CITY OF ALBUQUERQUE

August 17, 2018

RE: Los Diamantes
Engineer's Stamp Date: 08/26/15
Engineer's Certification Date: 08/14/18
Hydrology File: N09D013

Based on the information provided in your submittal received 08/14/18 and site visit on 08/16/18, the Engineer's Certification **is not** approved for ROFG/SIA for Hydrology. The following comments need to be addressed for approval of the above referenced project:

## EMERGENCY SPILLWAY DETAIL FOR TRACT B

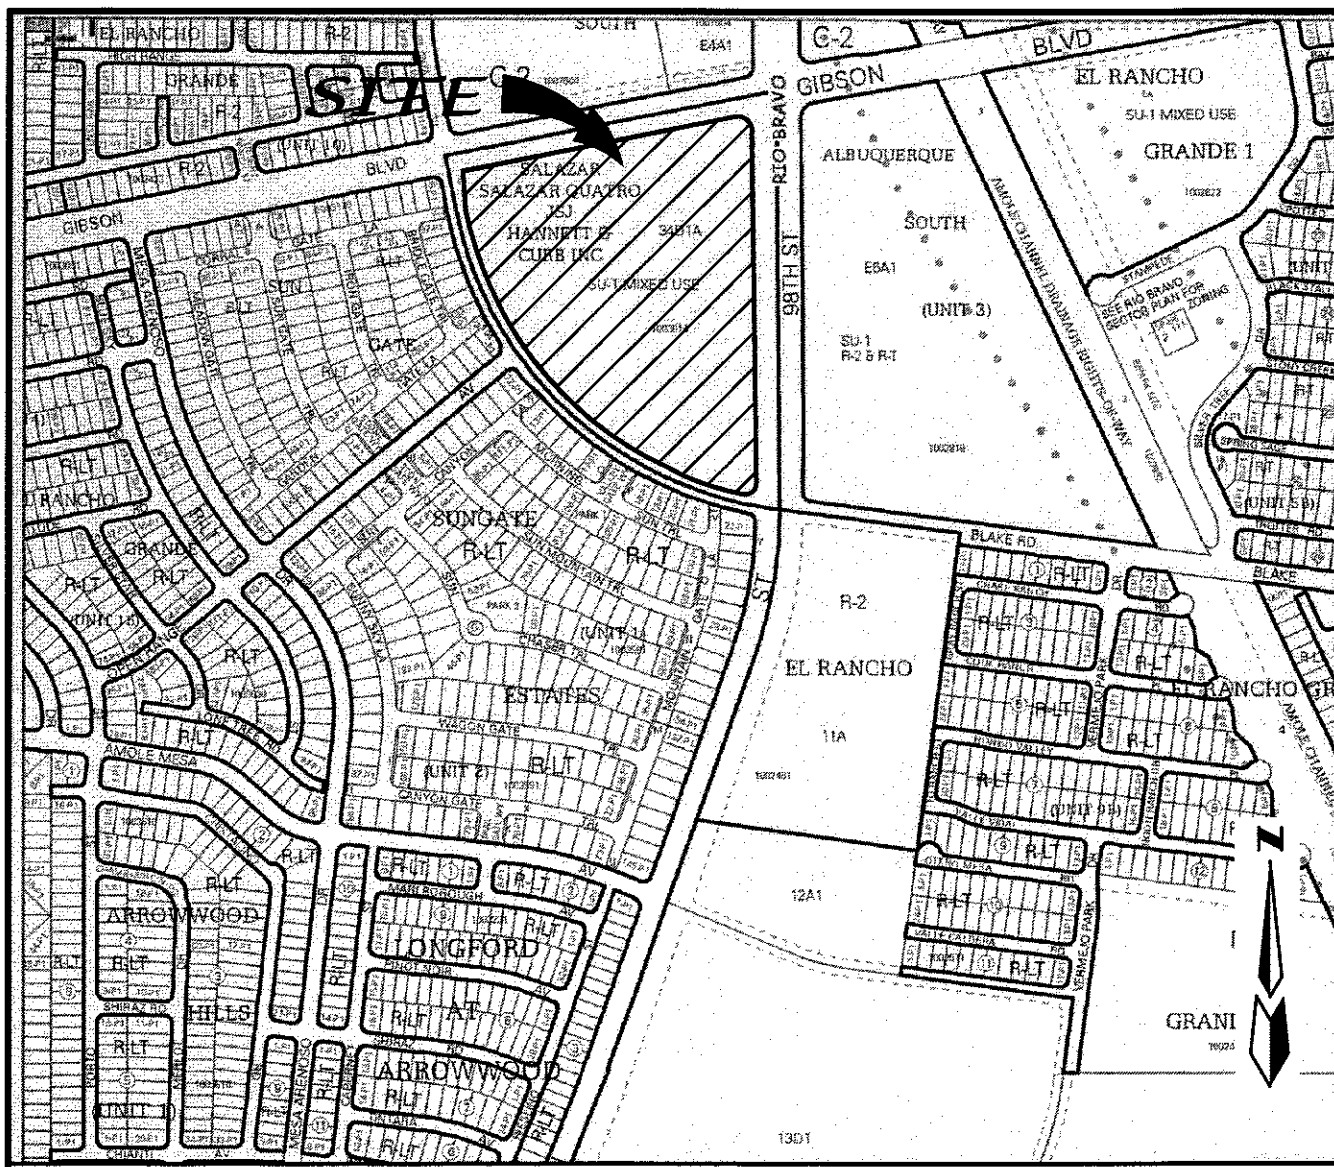
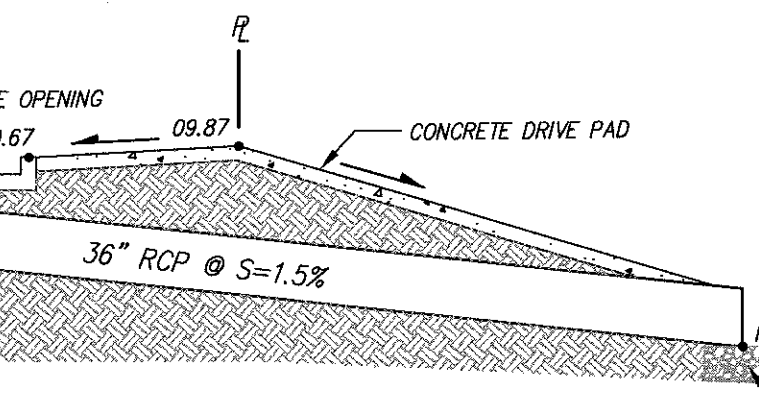
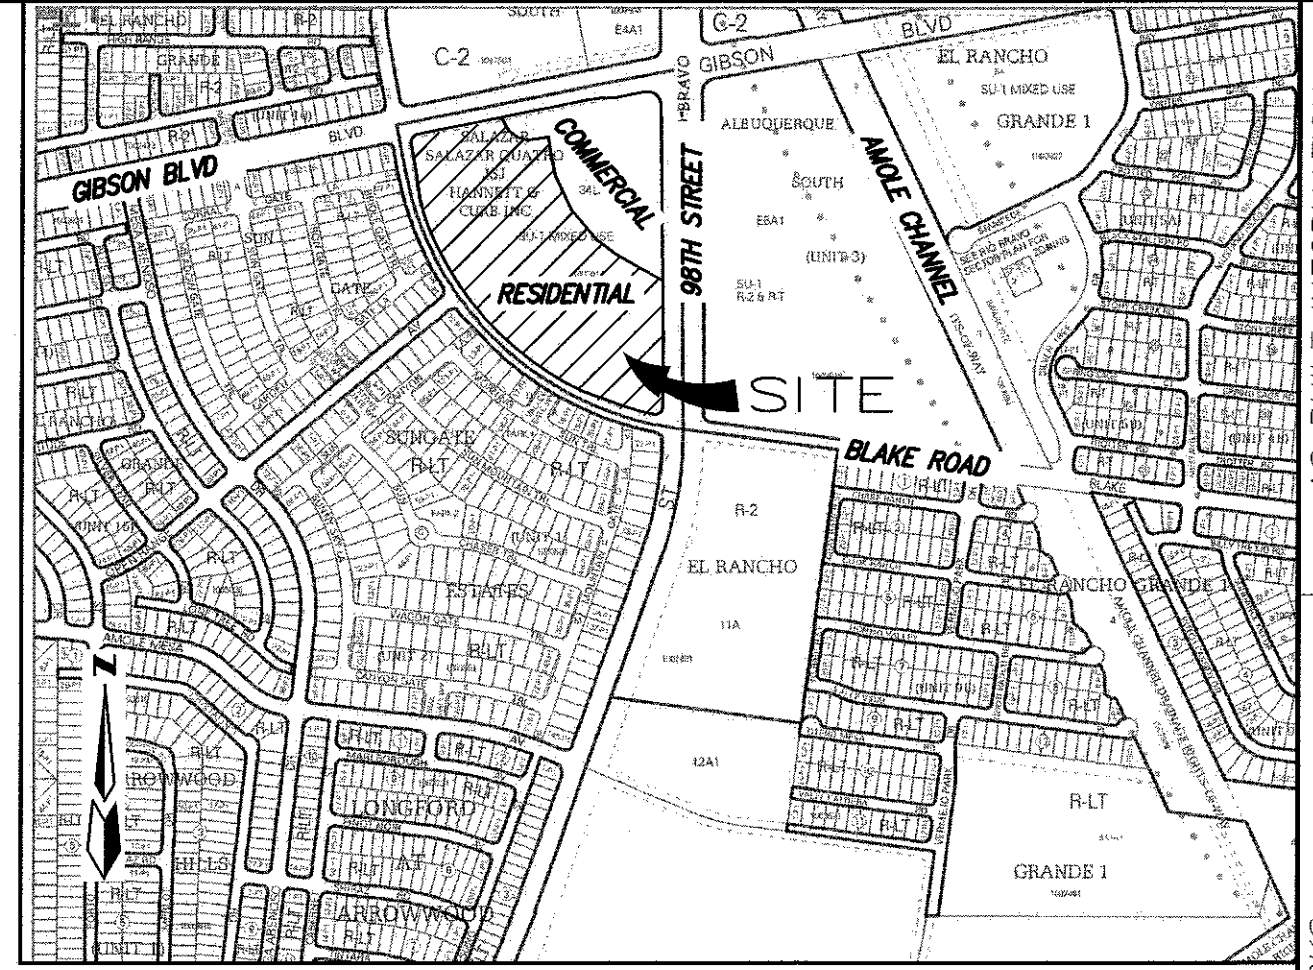
1. The pond needs to install the vehicular access gate & fence. (See attached pdf of Sheet 9 of the Record Drawings for Los Diamantes and the photos below.)

2. The pond needs to install the emergency spillway per the detail for Tract B. (See attached pdf of Sheet 9 of the Record Drawings for Los Diamantes and the photos below.)
